Application No: LU/240/21/PL
Site Address: 12 Cornwall Road Littlehampton BN17 6EE
Description of works: Change of Use from (C3) Dwelling house to 7 No. bed House in Multiple Occupation (Sui Generis)

Thank you for your internet representation made on 13th August 2021 which has been recorded as an objection with the comments as follows:

Drawing Title
Proposed Ground and First Floor Plans

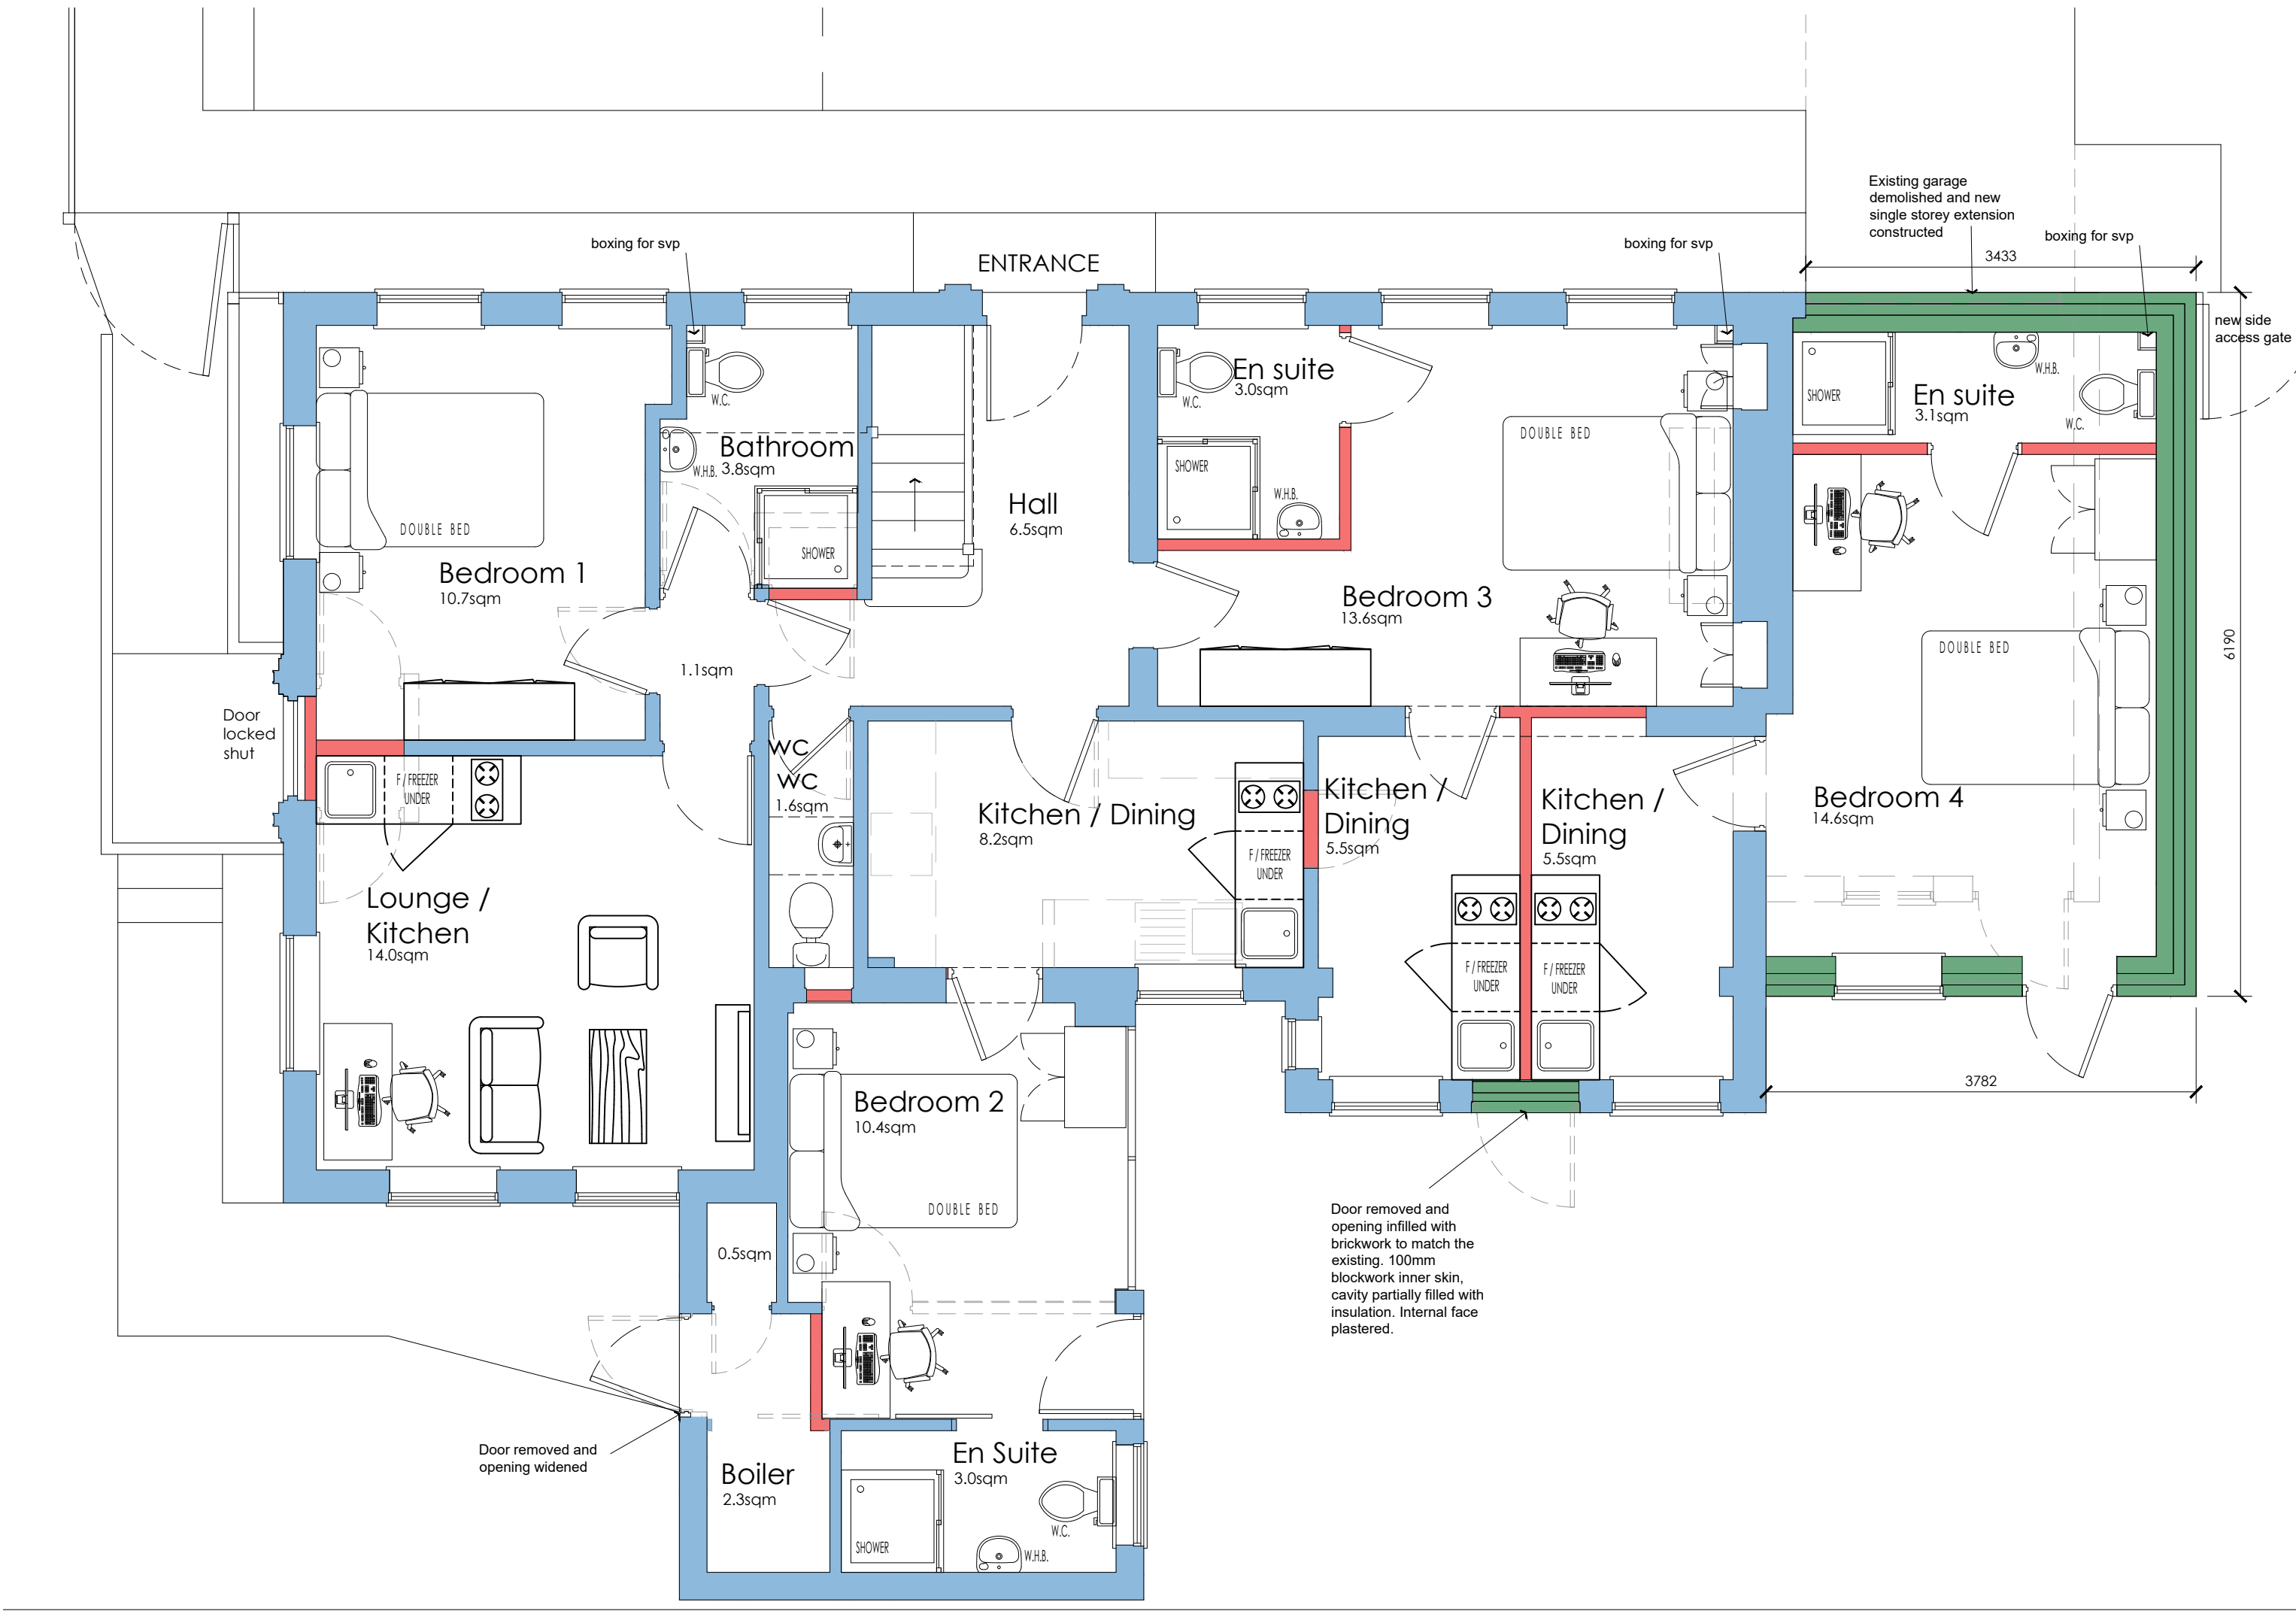
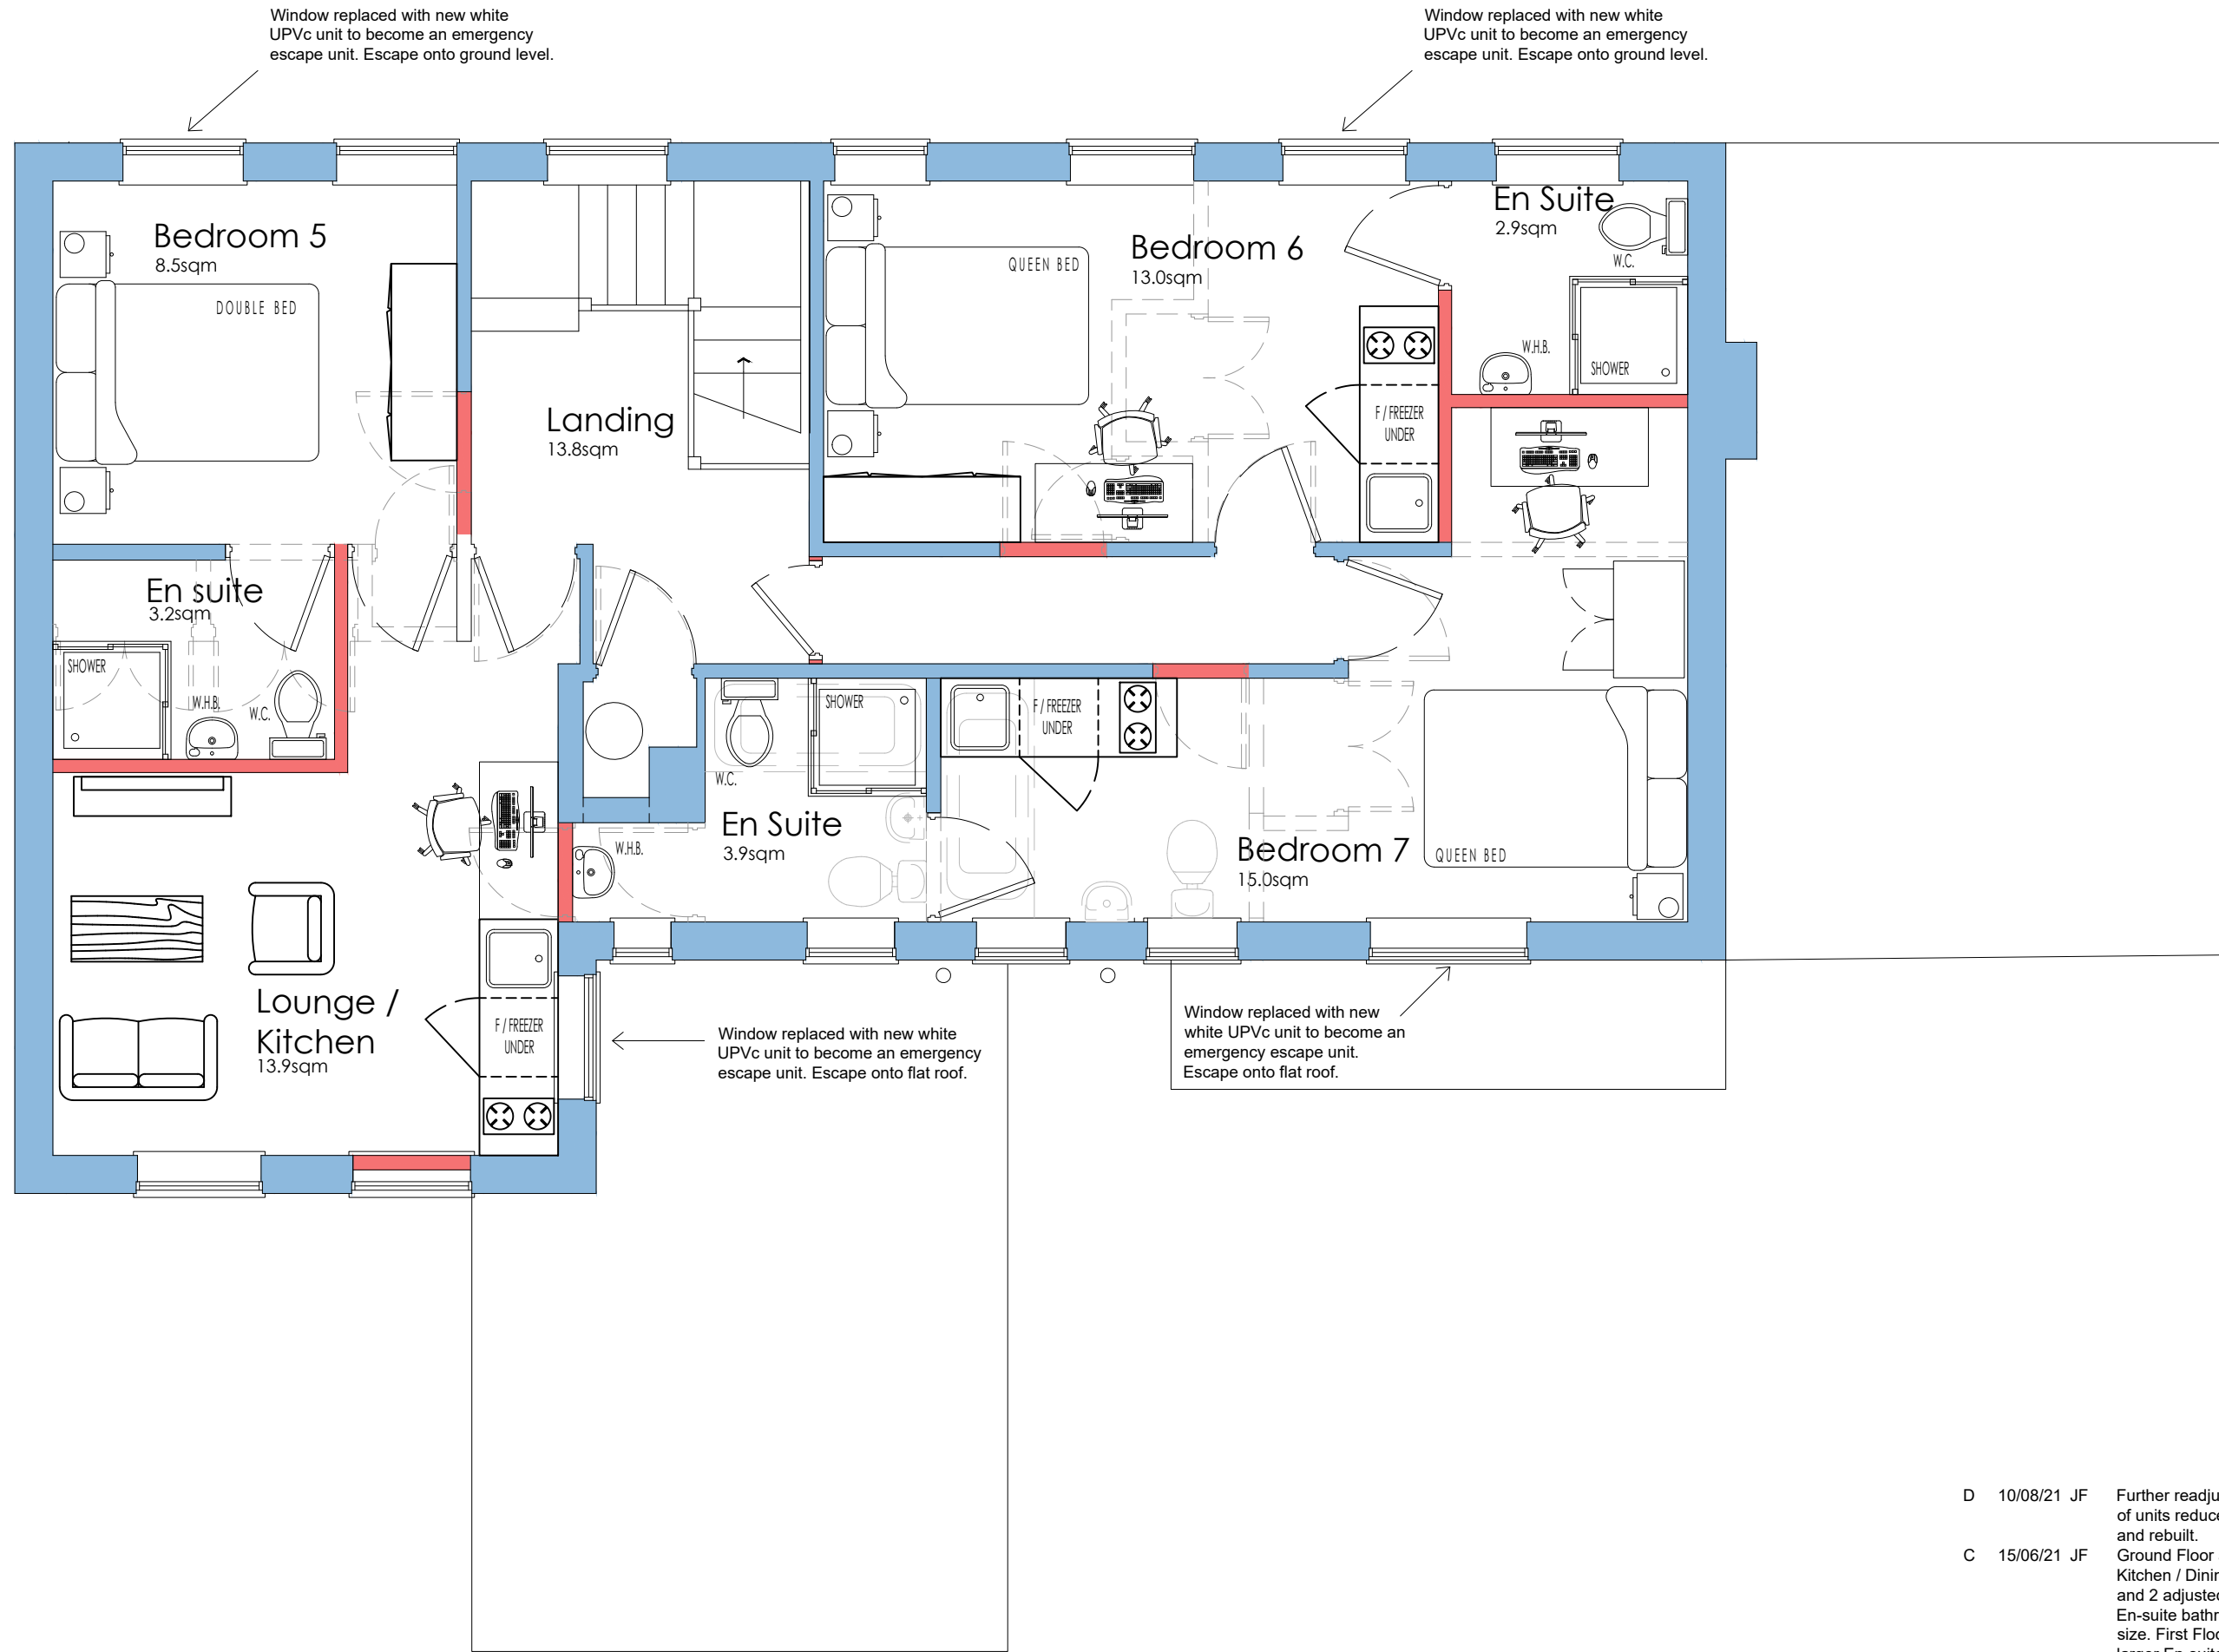
Although I support the desire for an increase in affordable housing in the area, I object to this development unless suitable arrangements are made for the impact of increased vehicular parking. I note that space has been allowed in the plans for 2 cars and 8 bicycles. I think it is naive to consider that only 2 cars would be applicable to the residents of 7 rooms and their visitors.
